BCA ASSESSMENT REPORT

**Oakdale Central
Sites 1C, 2B & 3
Milner Ave Horsely Park**

Revision 0
10 October 2013
Project No.: 130335

01 GROUND FLOOR PLAN
OFFICE ENTRY

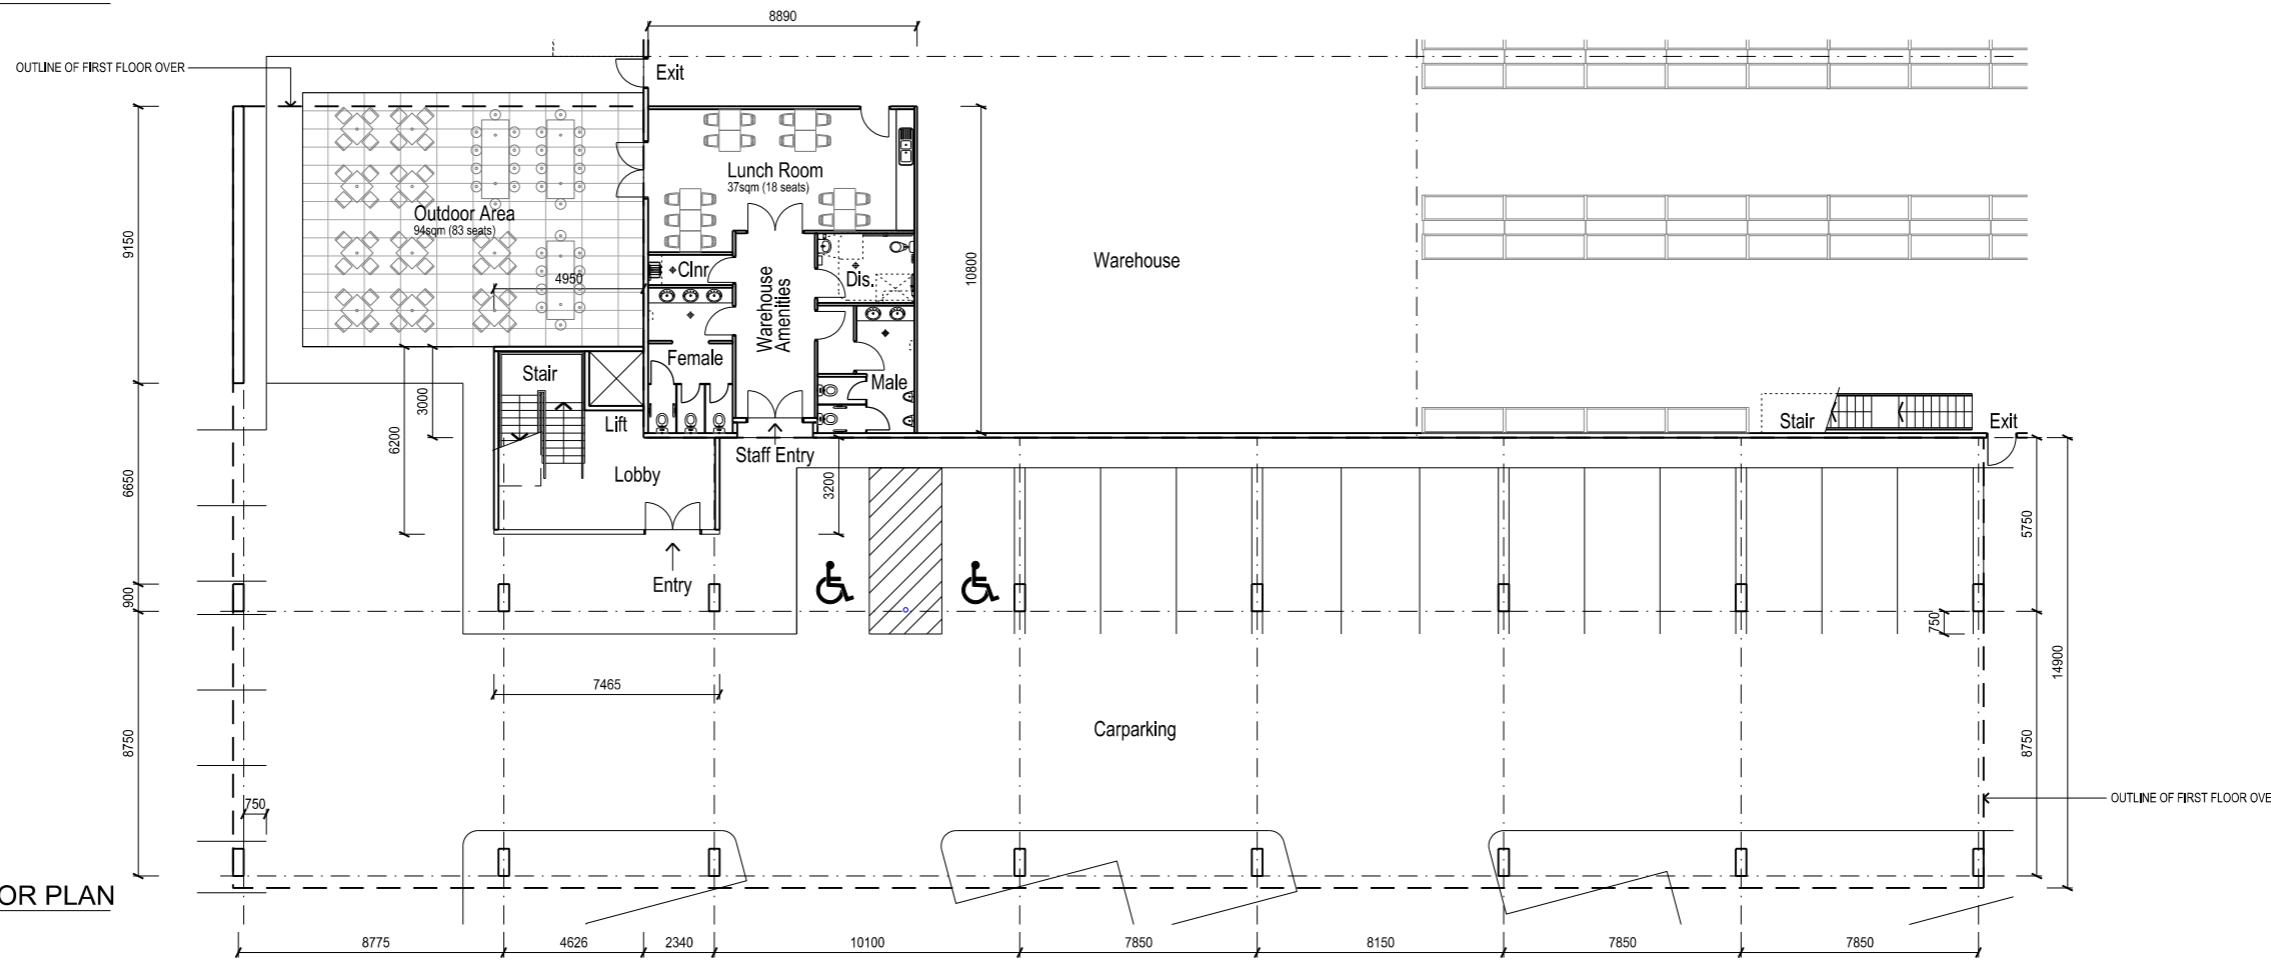
4.	D2.20	<p>The direction of swing for the following exit doors do not currently comply with the BCA DTS provisions (i.e. they do not swing in the direction of egress):</p> <ul style="list-style-type: none"> + Lobby Entry Doors at Ground Floor – Maximum travel distance of 95m to one of two alternative exits (in lieu of BCA DTS maximum of 40m). + Staff Entry doors at Ground Floor.
Site 3

01 OFFICE - GROUND FLOOR PLAN

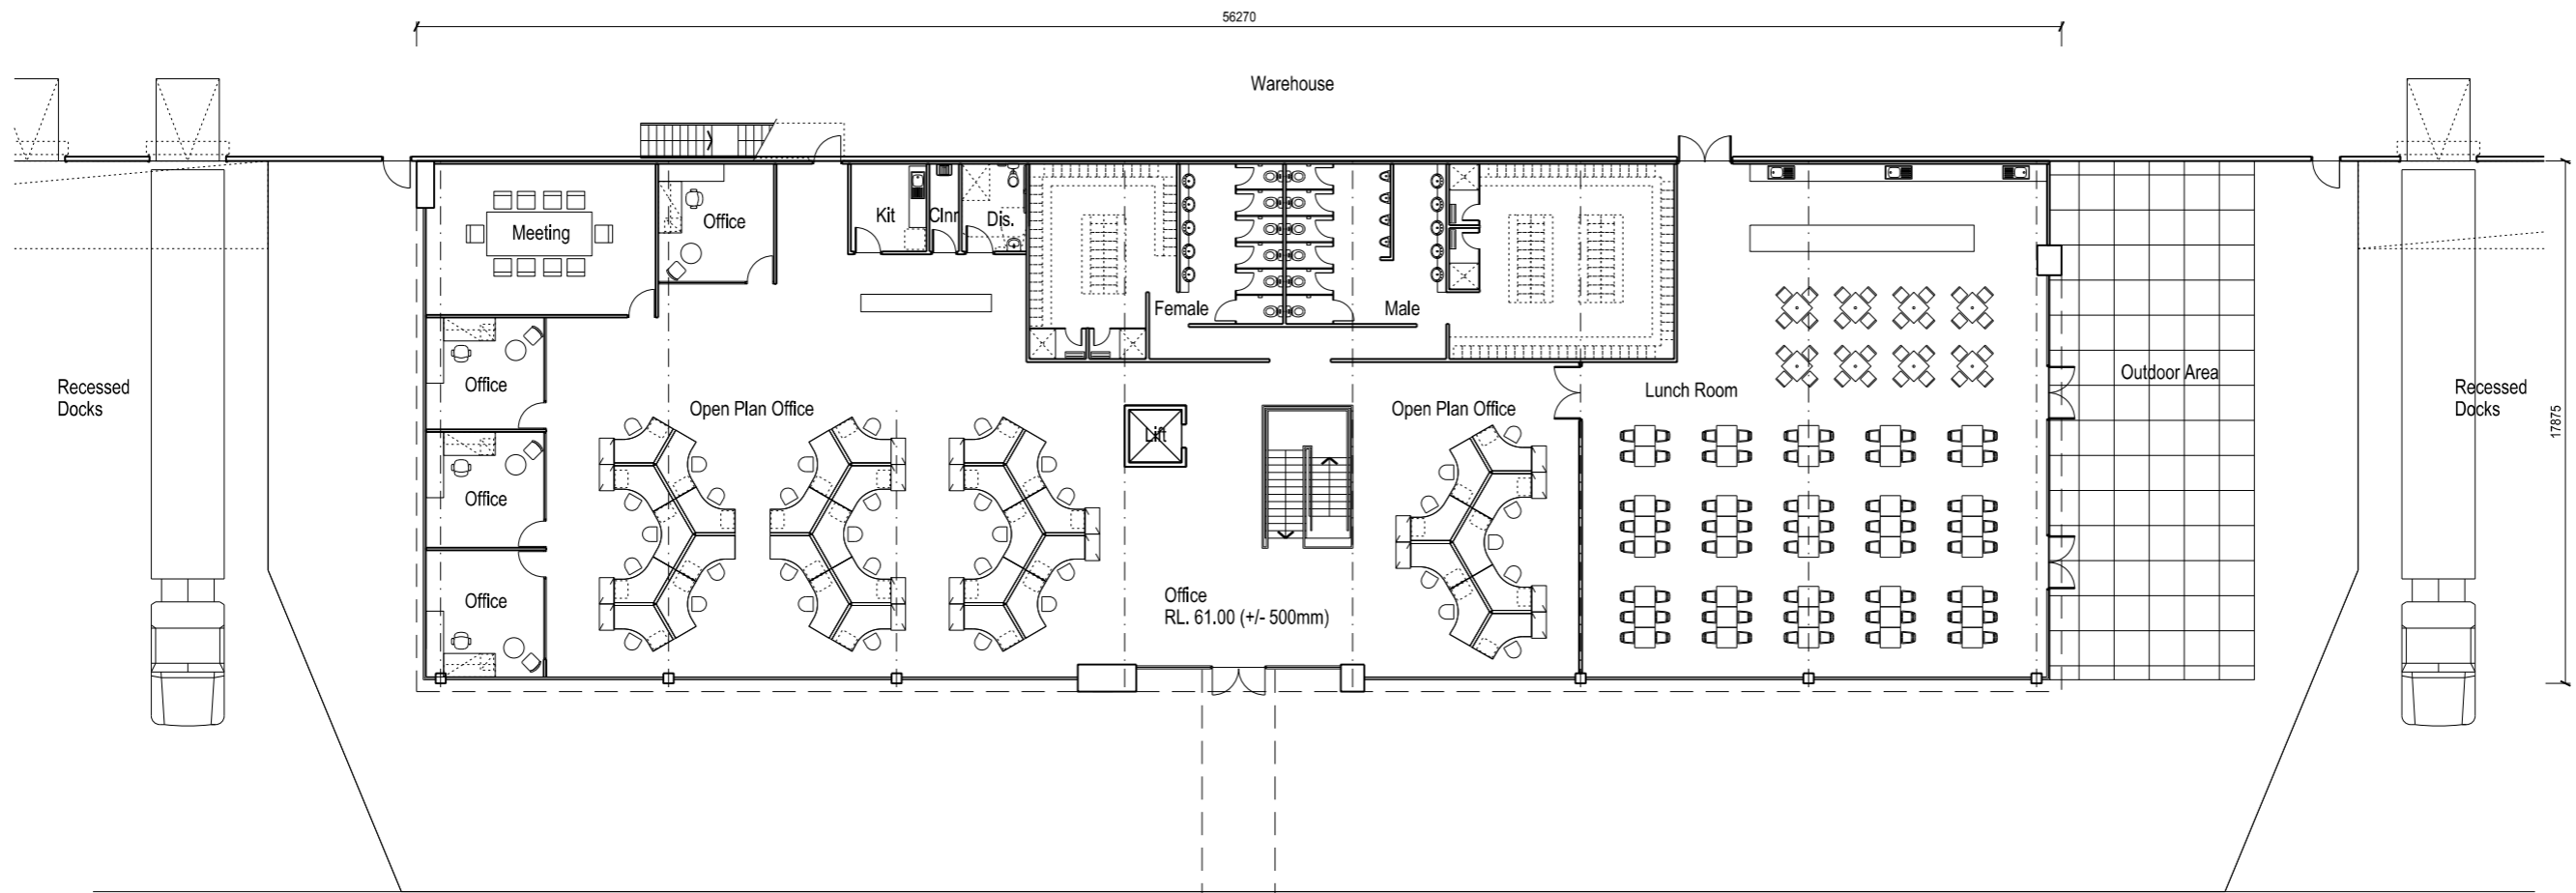
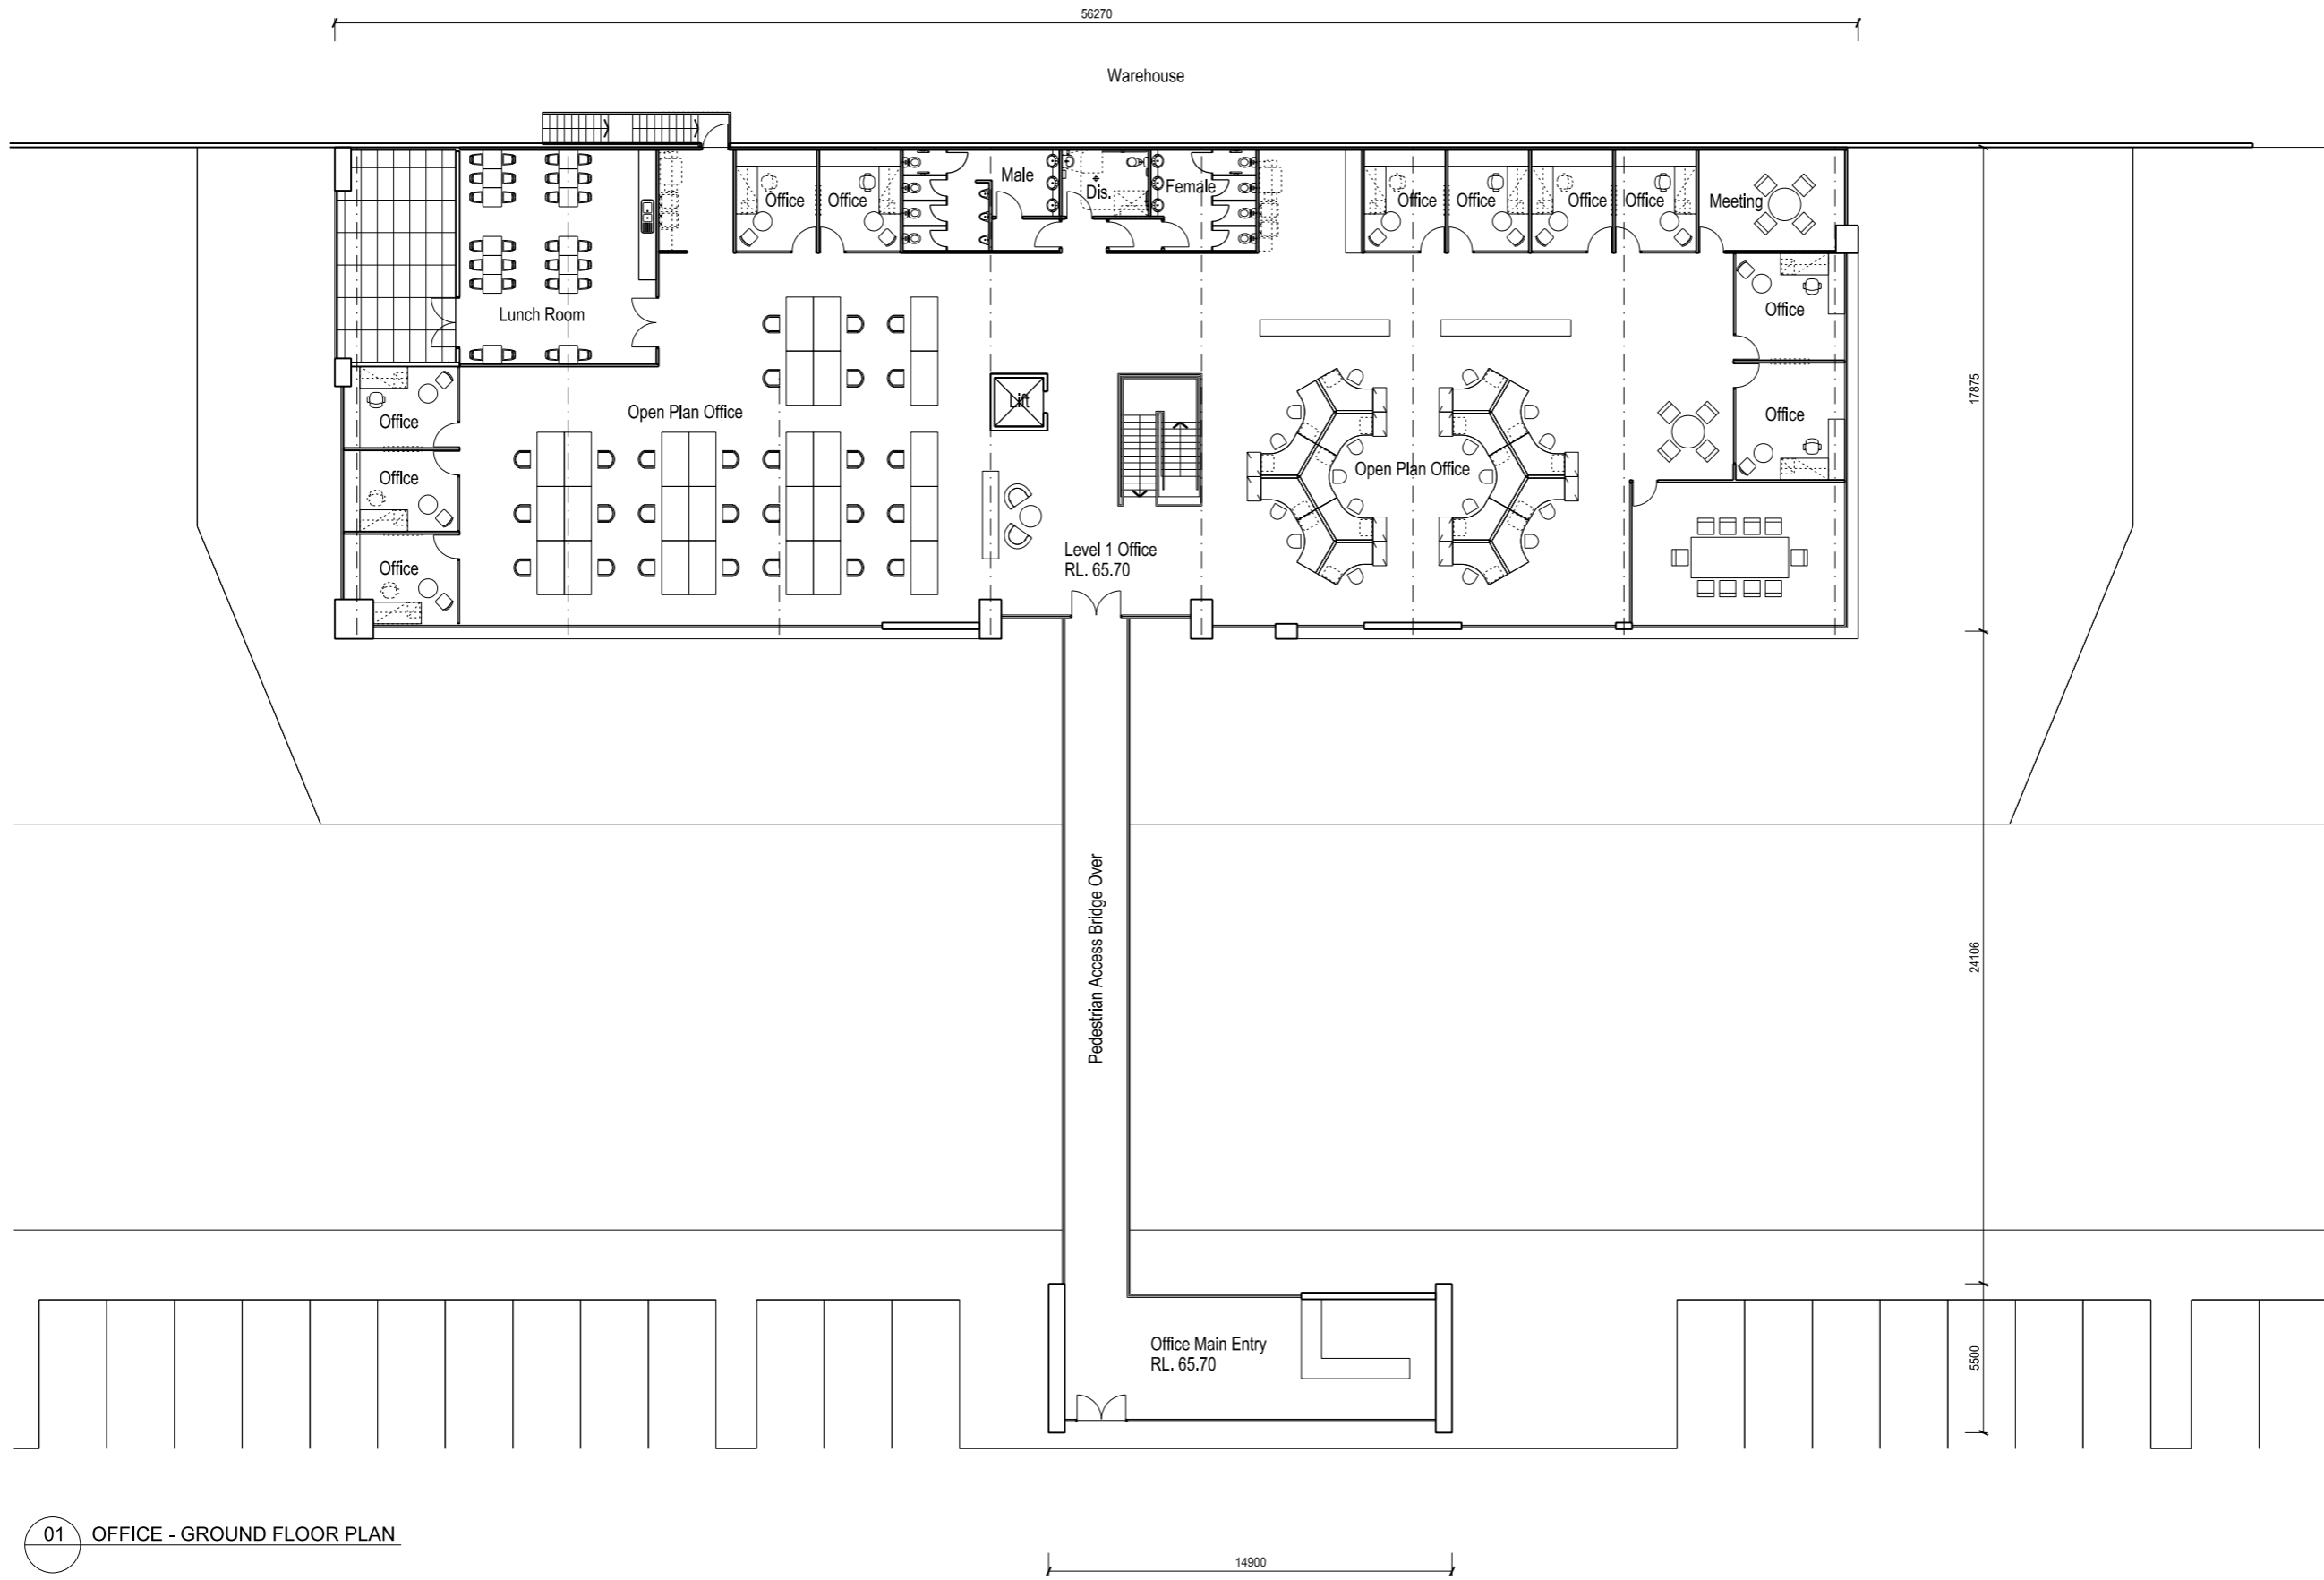
5.	D2.20	<p>The direction of swing for the following exit door does not currently comply with the BCA DTS provisions (i.e. they do not swing in the direction of egress):</p> <ul style="list-style-type: none"> + Office Main Entry at Ground Floor (RL 65.70).
